**Block 4B Central Park Adaptive Reuse
(SSD 9374 and MP06_0171 MOD 16)**

I refer to the above modification request and SSD application for Block 4B Central Park. Further to the letter requesting a response to submissions (RTS) dated 8 November 2019, the Department requests that you respond to the submissions received from the City of Sydney and Heritage NSW which are available on the Department's website:

Figure 59 – Extract of Proposed Eastern Elevation

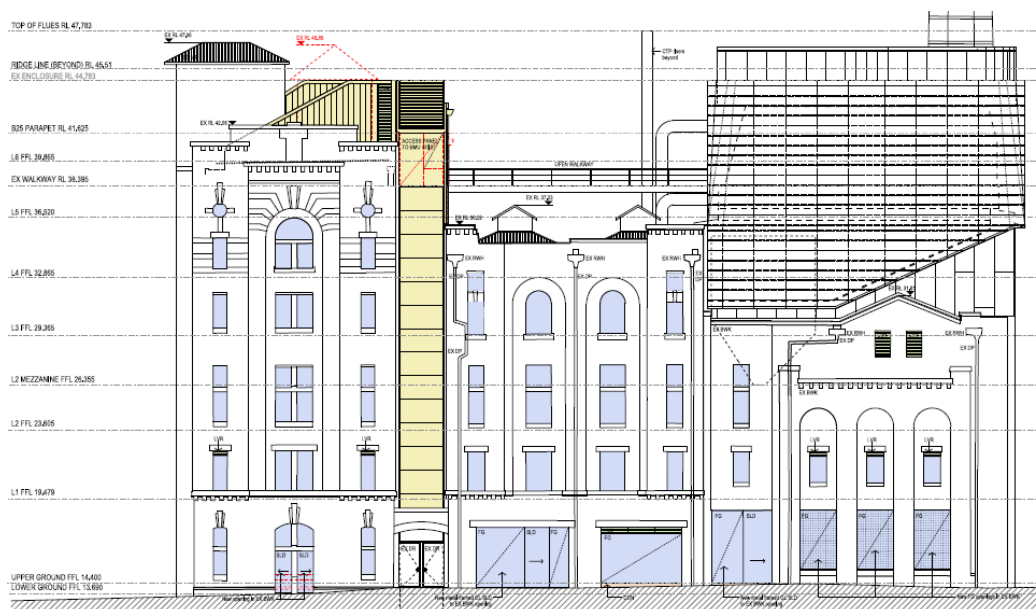
- the extent of intervention to the building fabric and protection of heritage value of the building and site
- the design integrity of the northern façade and the northern part of the eastern façade.
